# Response to 6/2021/3422/MAJ – Salisbury Square

TITLE: REFUSE SWEEP PATH ANALYSIS

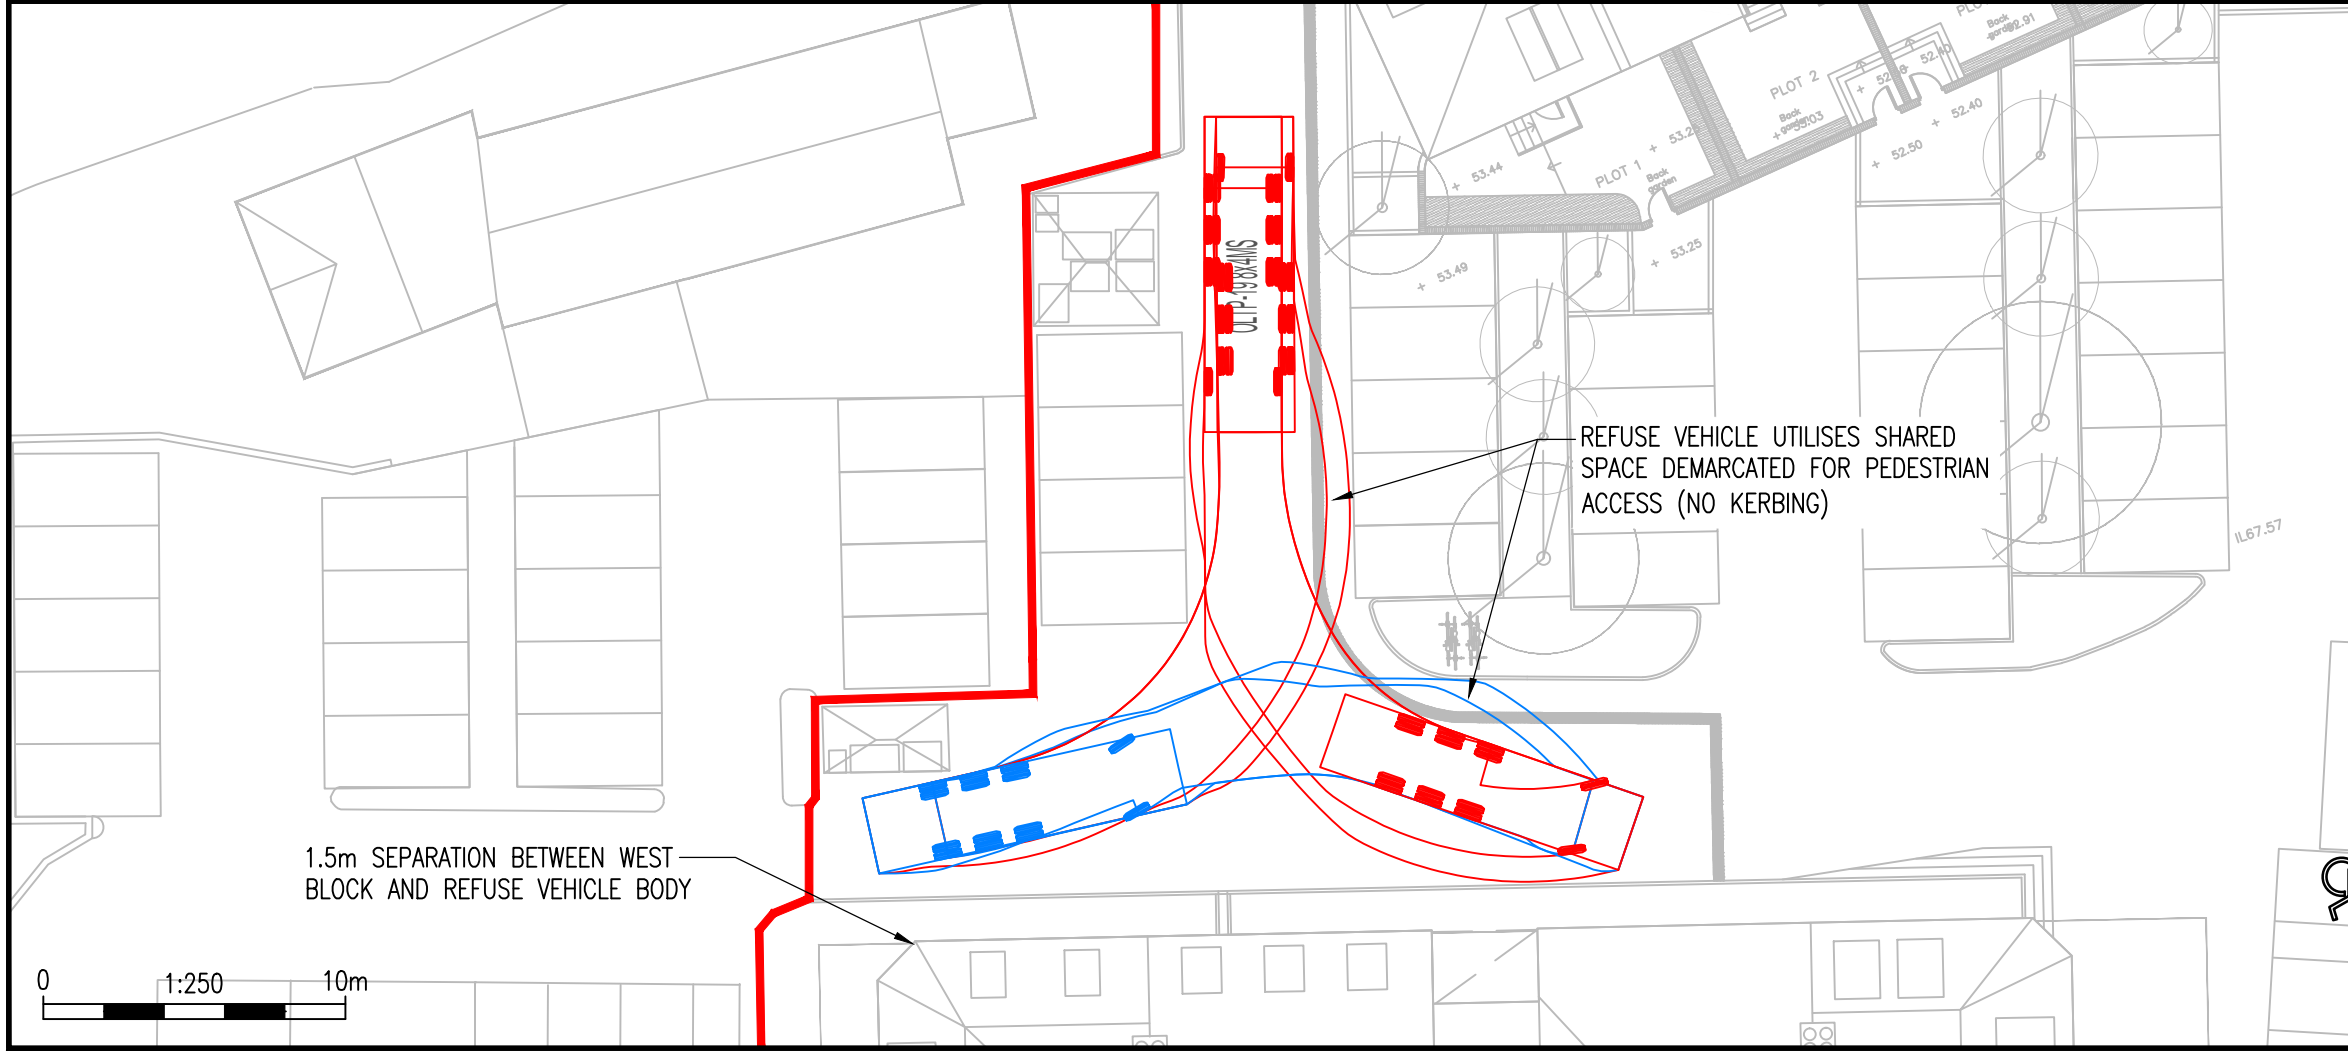
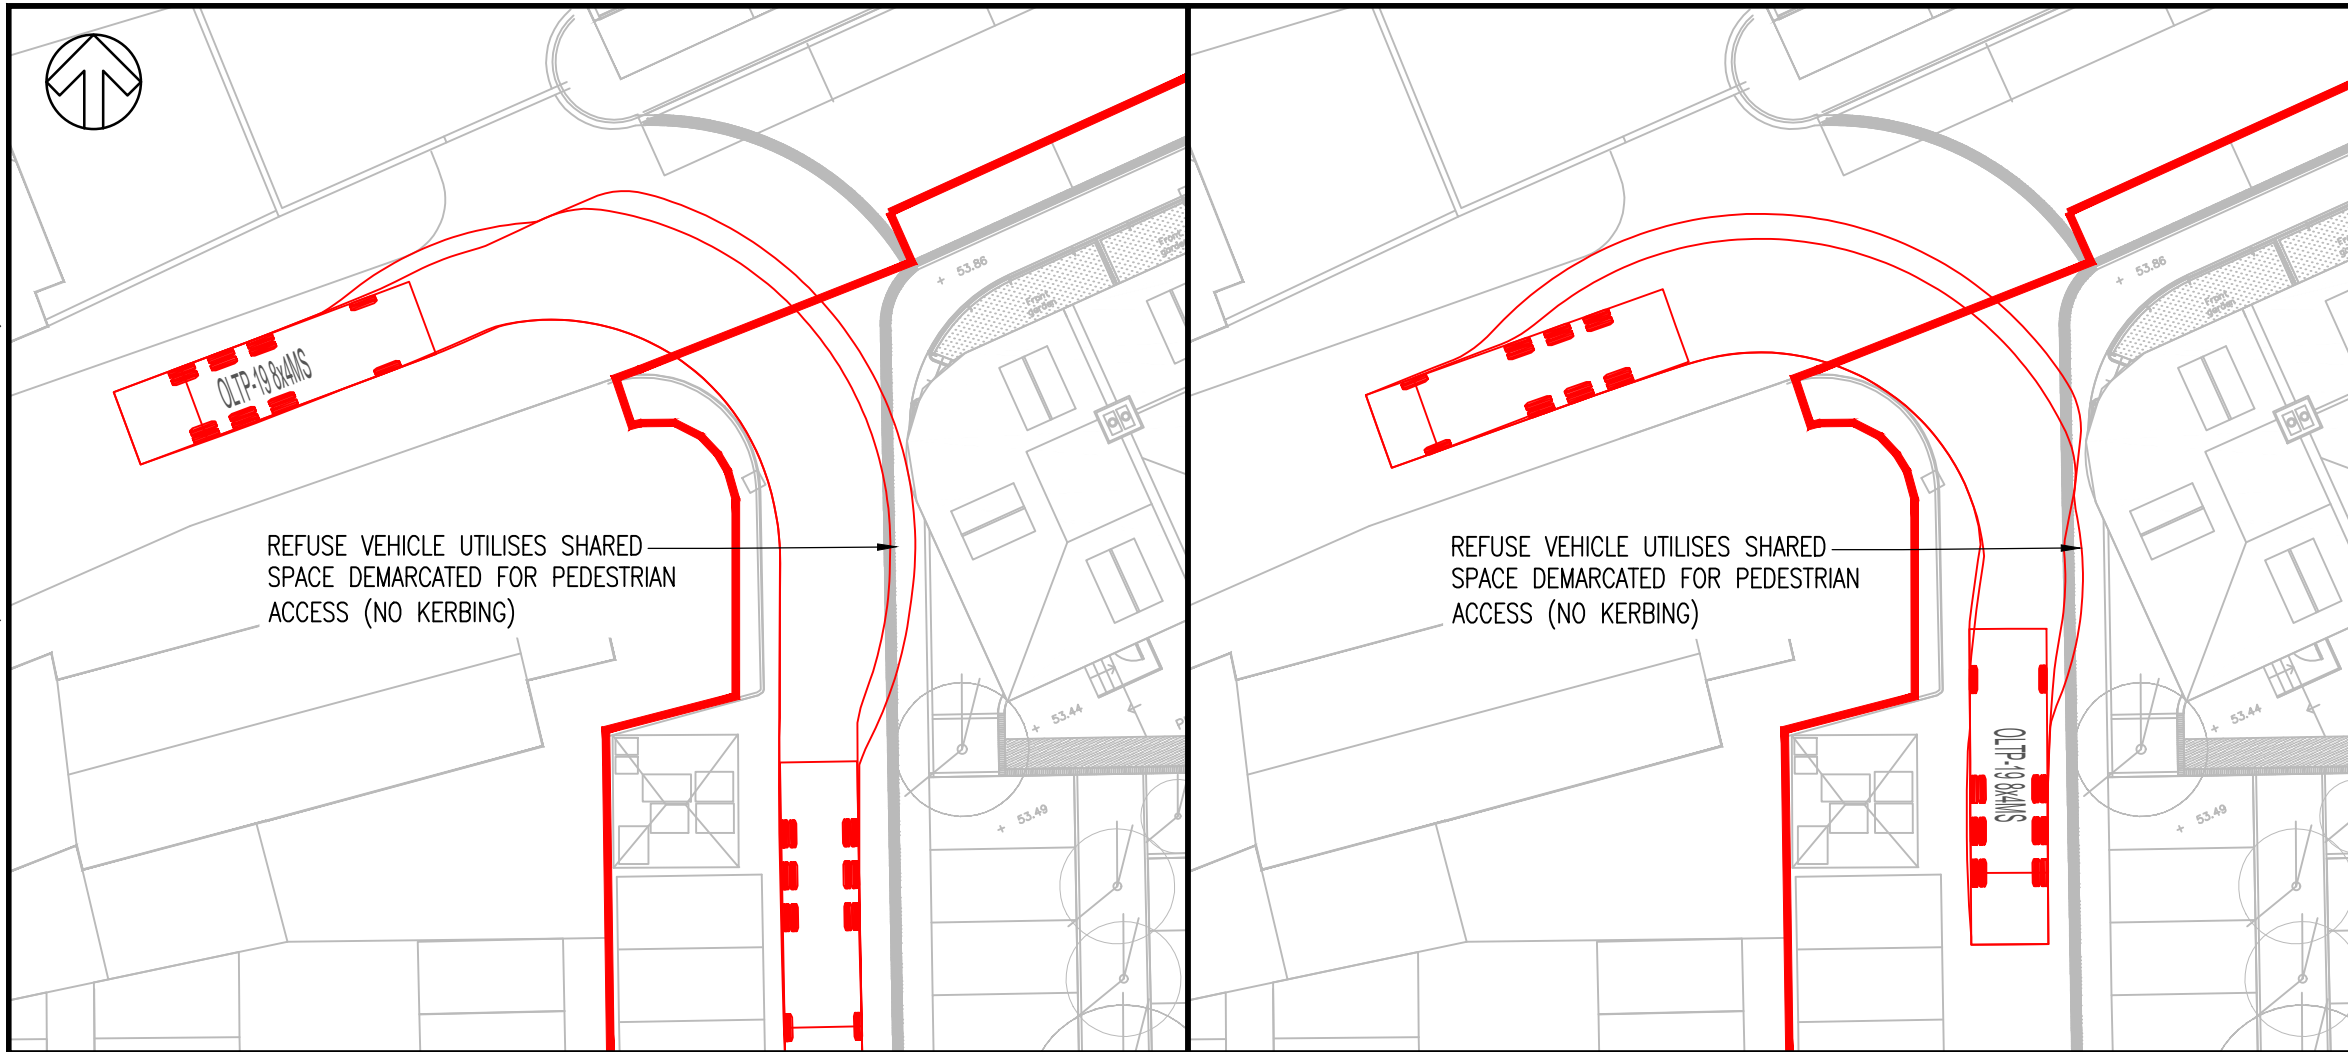
The swept path analysis shows there is only just room to get commercial vehicles into the car park area for deliveries, waste collection and in emergencies.

It is unclear where delivery vehicles will park when off-loading deliveries for businesses in the main block and difficult to see where this can be done, without impeding traffic flow / blocking parking spaces.

Clarification is needed, to ensure the space is available within the current layout.
